Application No: 3/2021/0660 AND 3/2021/0661

Location: BOWLAND SECTION AND MARL HILL SECTION. WORKS AT VARIOUS LOCATIONS.

Proposal: PROPOSED WORKS FOR AND USE OF REPLACEMENT SECTION OF AQUEDUCT, INCLUDING EARTHWORKS AND ANCILLARY INFRASTRUCTURE INCLUDING: A NEW VALVE HOUSE BUILDING WITHIN FENCED COMPOUND WITH PERMANENT VEHICULAR ACCESS PROVISION. WITH THE INSTALLATION OF A TUNNEL PORTAL AND AN OPEN CUT CONNECTION AREA WITHIN A TEMPORARY CONSTRUCTION COMPOUND, TO INCLUDE SITE ACCESSES, STORAGE AREAS, PLANT AND MACHINERY, AND DRINAGE INFRASTRUCTURE AND A TEMPORARY HAUL ROUTE WITH BRIDGE OVER THE RIVER HODDER. IN ADDITION, A TEMPORARY HAUL ROUTE WITH BRIDGE OVER THE RIVER RIBBLE (AS ONE OF TWO OPTIONS FOR VEHICULAR ACCESS TO THE TEMPORARY CONSTRUCTION COMPOUND); A SERIES OF LOCAL HIGHWAY WORKS TOGETHER WITH A TEMPORARY SATELLITE PARK AND RIDE FACILITY AND A VEHICLE MARSHALLING AREA.

SCALE N.T.S.	SHEET SIZE A3
DRAWING NUMBER RVBC-BO-APP-004-12_12	REVISION 0

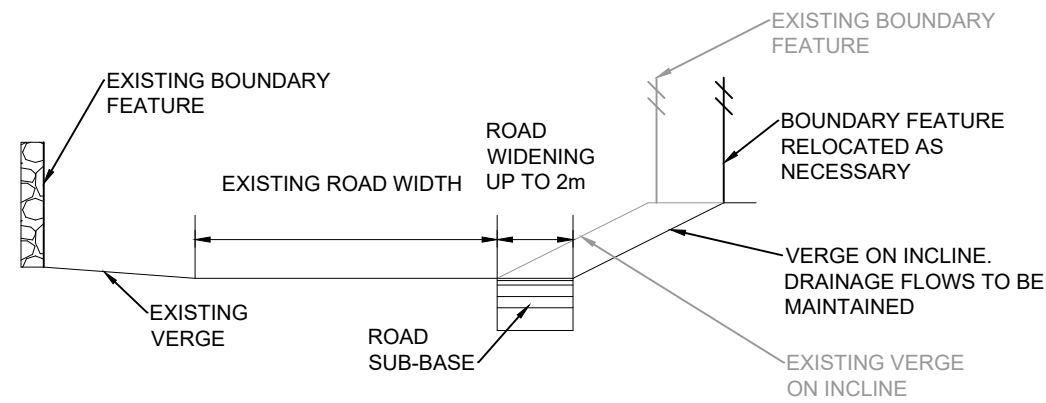
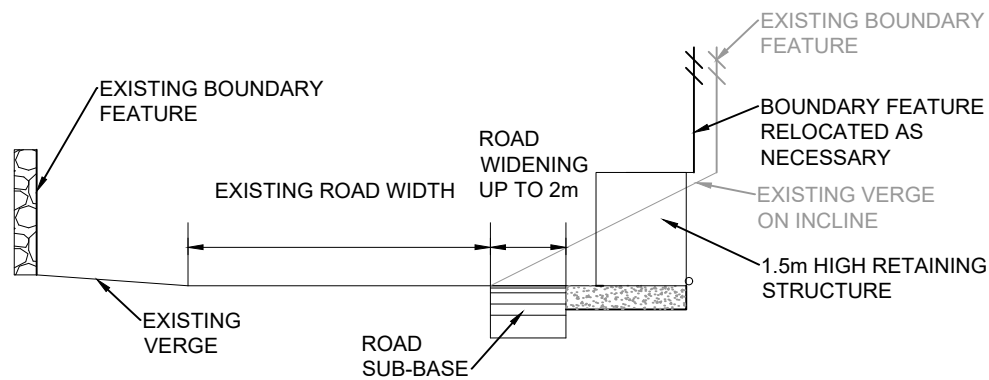
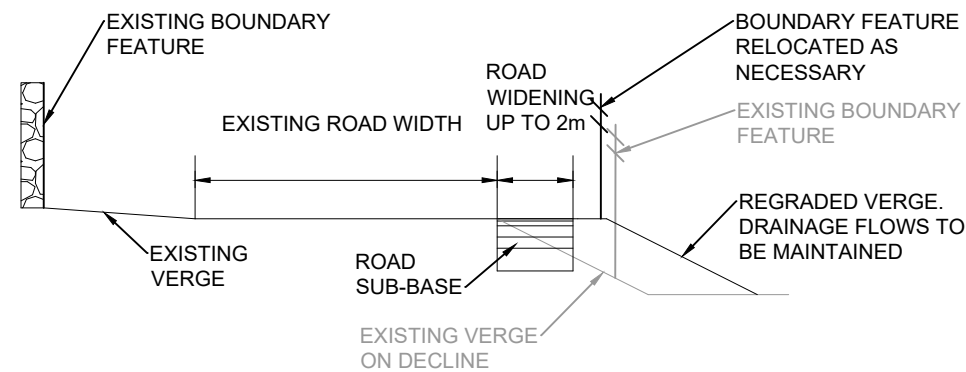
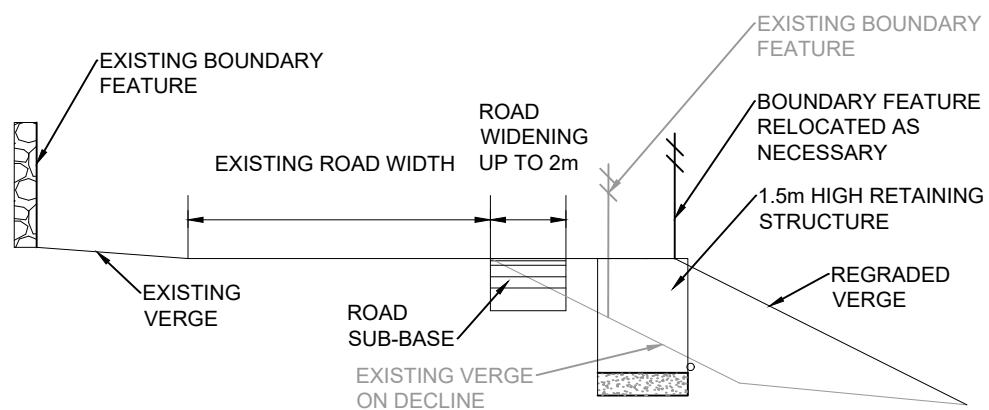
Along this section of route there are 22 road widenings proposed. After reviewing the location of the proposed widenings, a number of which are clearly required and others that appear to provide limited/no benefit.

- Those that should be constructed prior to the project are: RW12, RW15, RW16, RW23, RW24, RW26 and RW28. Once verge and foliage has been cut back, as suggested above, and the edge of the carriageway has been identified, some widenings as proposed may not be required, and others may be required (as a consequence of the SPA's background mapping being inaccurate).

- Proposed widenings, where possible, should not be on the same side as existing ditches, e.g., RW19 should be moved to the opposite side of the carriageway.
Note: to overcome safety issues, additional works will be required where widenings are proposed on the same side as ditches.

- All widenings are subject to detailed design having regard to infrastructure, carriageway alignment, topography, speeds and safety, e.g., RW28 may require lengthening and signage currently exists at RW26.

- I do not fully agree with the locations of some of the proposed widenings, e.g.,
 - o a pinch point appears north of RW09 rather than where it is proposed

- o RW22 would be more beneficial if was provided at the apex of the bend, and
 - o there may be a need for widening north of the Braddup compound access.
